WEST SUSSEX COUNTY COUNCIL CONSULTATION

TO:	Arun District Council FAO: Michael Eastham
FROM:	WSCC - Highway Authority: Public Rights of Way
DATE:	02nd December 2020
LOCATION:	Land South of Ford Lane east of North End Road Yapton Arundel BN18 0DS
SUBJECT:	Y/131/20/DOC Approval of details reserved by condition imposed under ref APP/C3810/W/17/3170059 (Y/80/16/OUT) relating to Condition Nos 7 - means of access/egress onto Ford Lane, 8 - retention & improvement of Public Rights of Way 357, 358, 359 & new cycle & pedestrian routes, 9 - Stage 1 Road Safety Audit, 12 - Travel Plan and 17 - Phase 1 Habitat Survey
DATE OF SITE VISIT:	n/a
RECOMMENDATION:	Advice
S106 CONTRIBUTION TOTAL:	n/a

1. Condition 8 (retention and improvement to Public Rights of Way 357, 358 and 359 and new cycle and pedestrian routes)

PUBLIC RIGHT OF WAY SURFACE DETAILS:

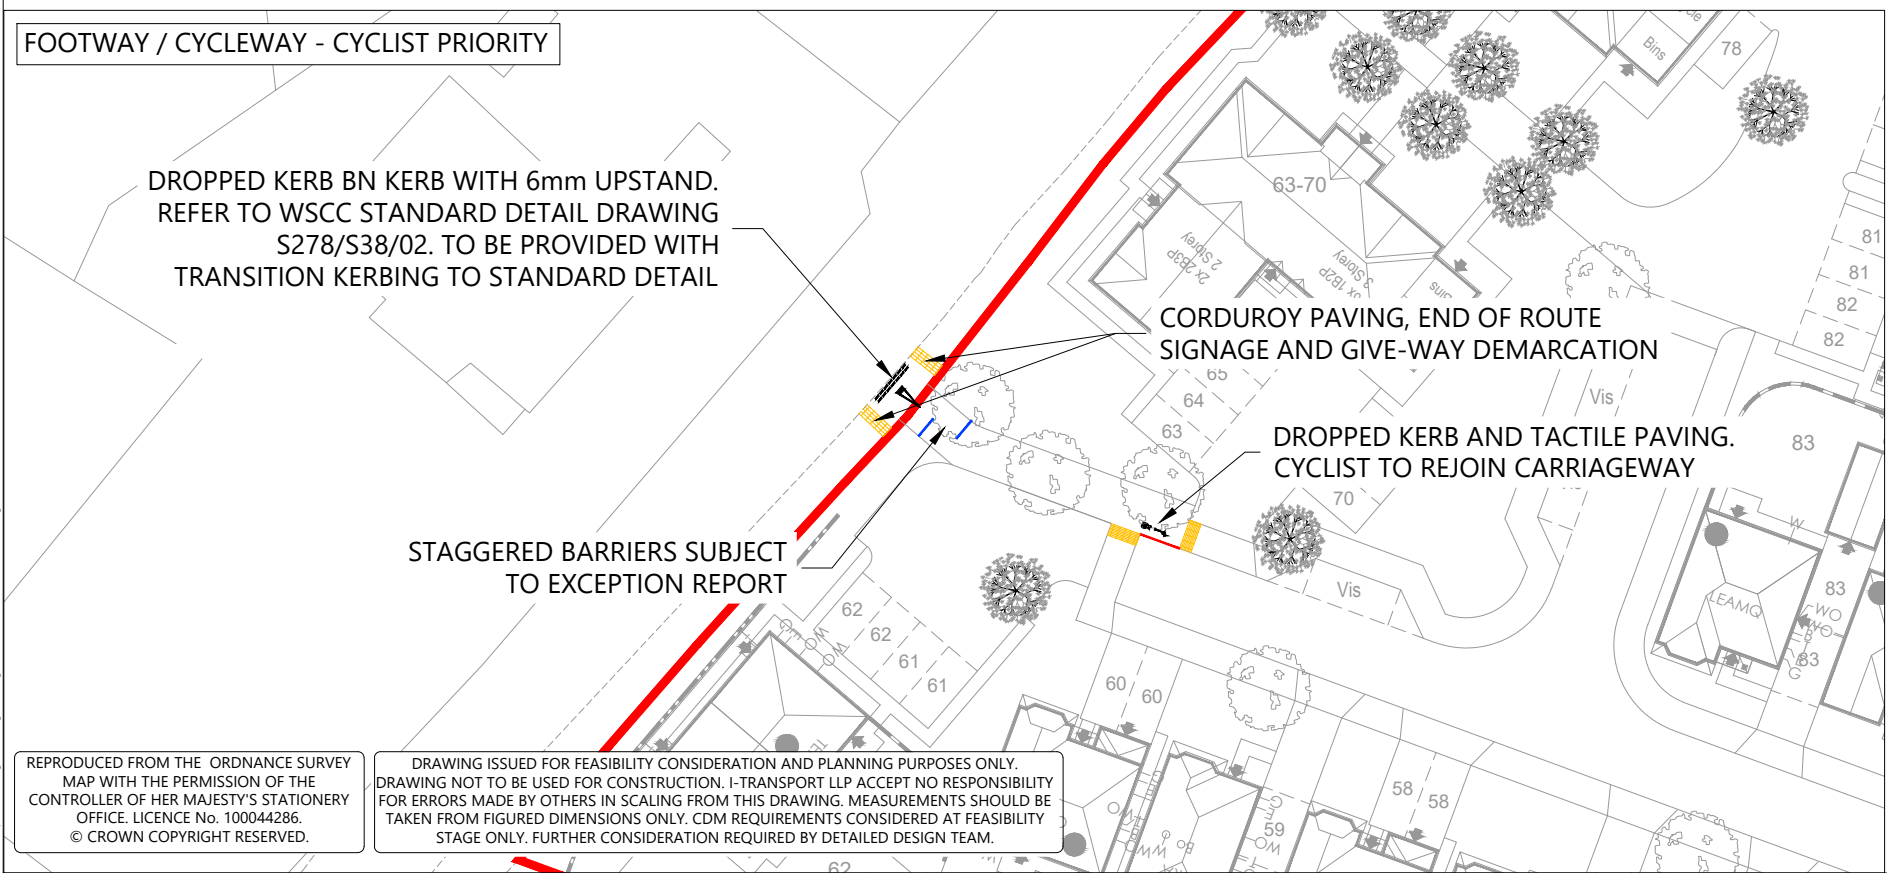
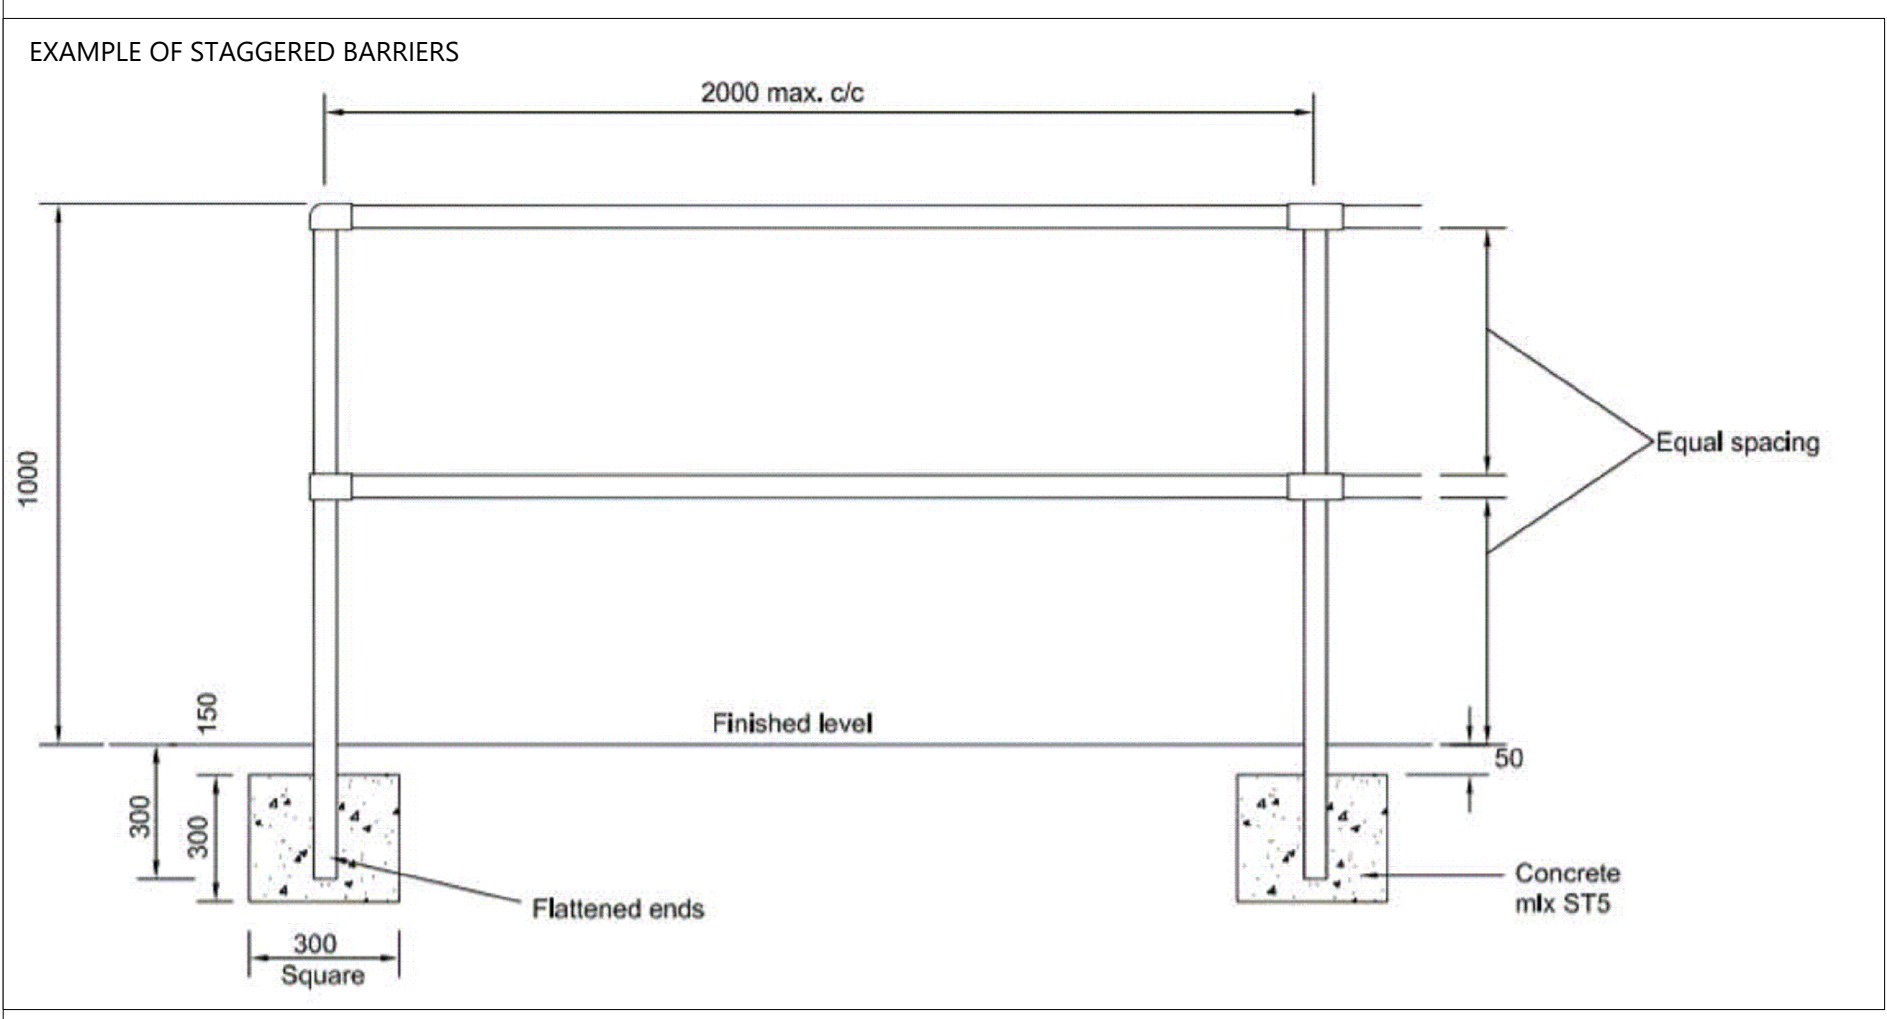
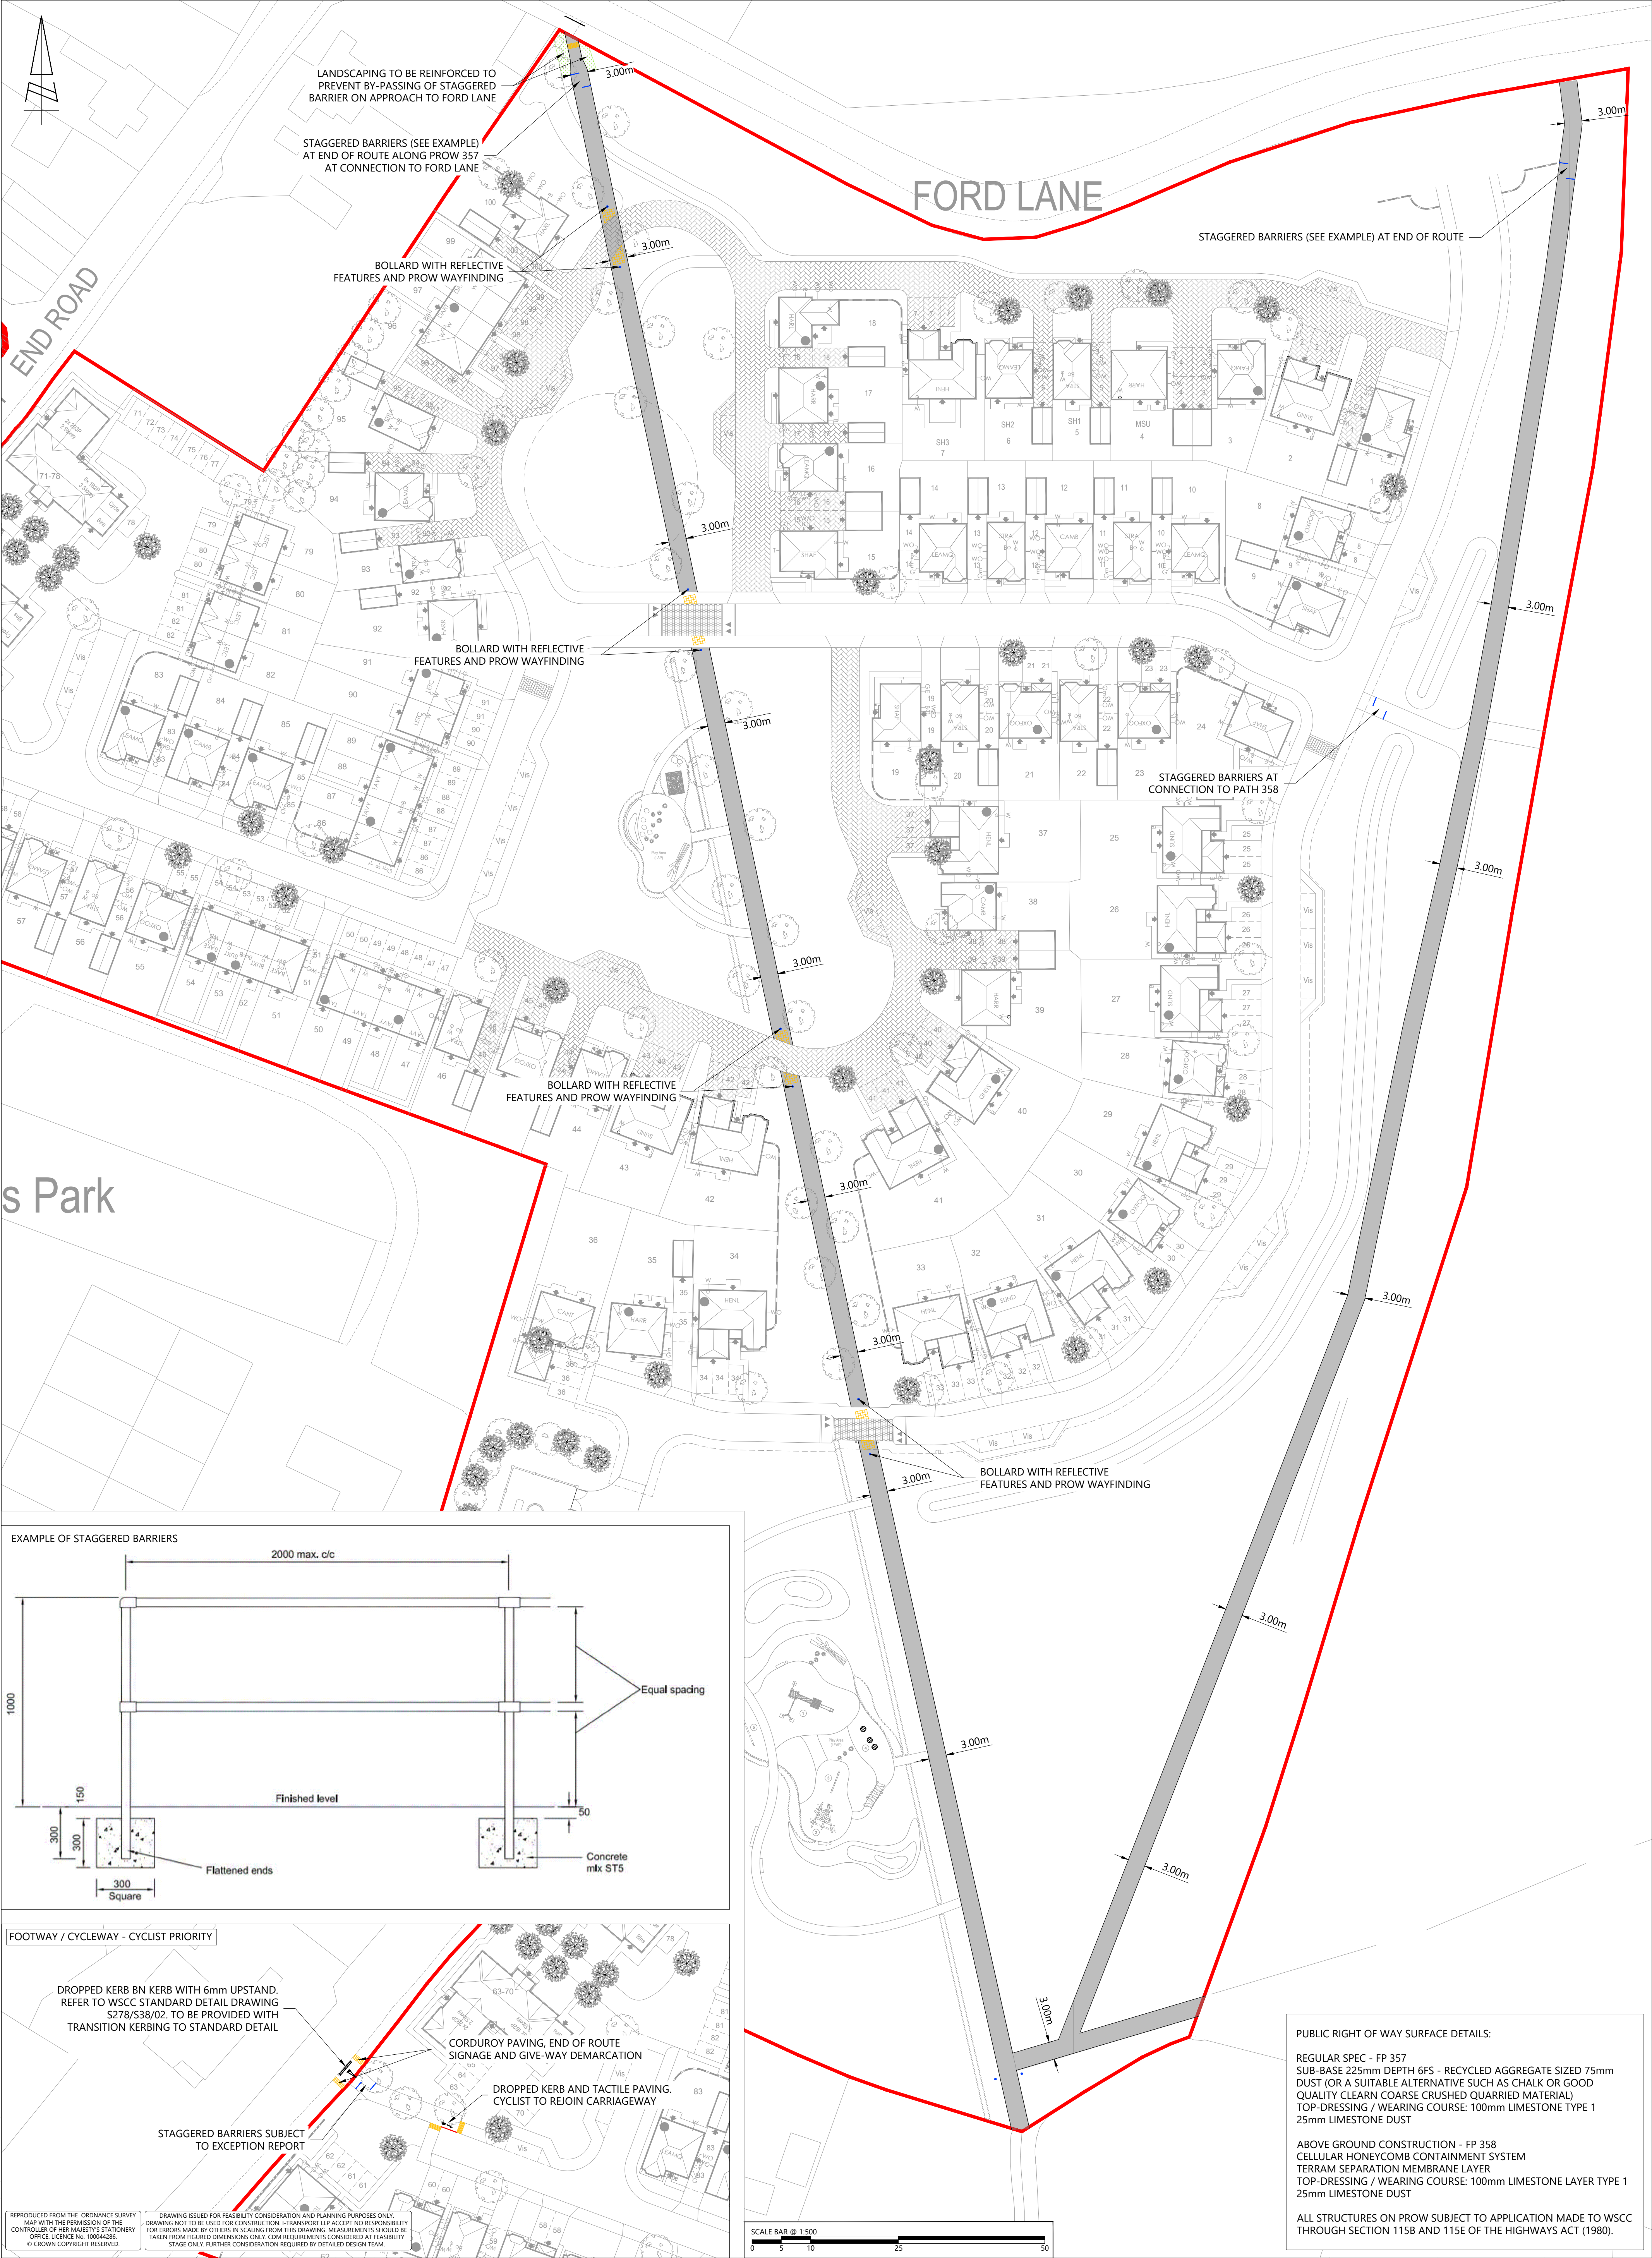
Should both routes be formally dedicated as Bridleways we would seek 3m minimum width and surfacing as per our specification which will require specific materials to meet equestrian needs. If FP357 is to allow cycling and pedestrian access only, the surfacing material will not need this specific type but can be agreed in due course. It will however still require a minimum of 3m to ensure safe separation between cyclists and pedestrians.
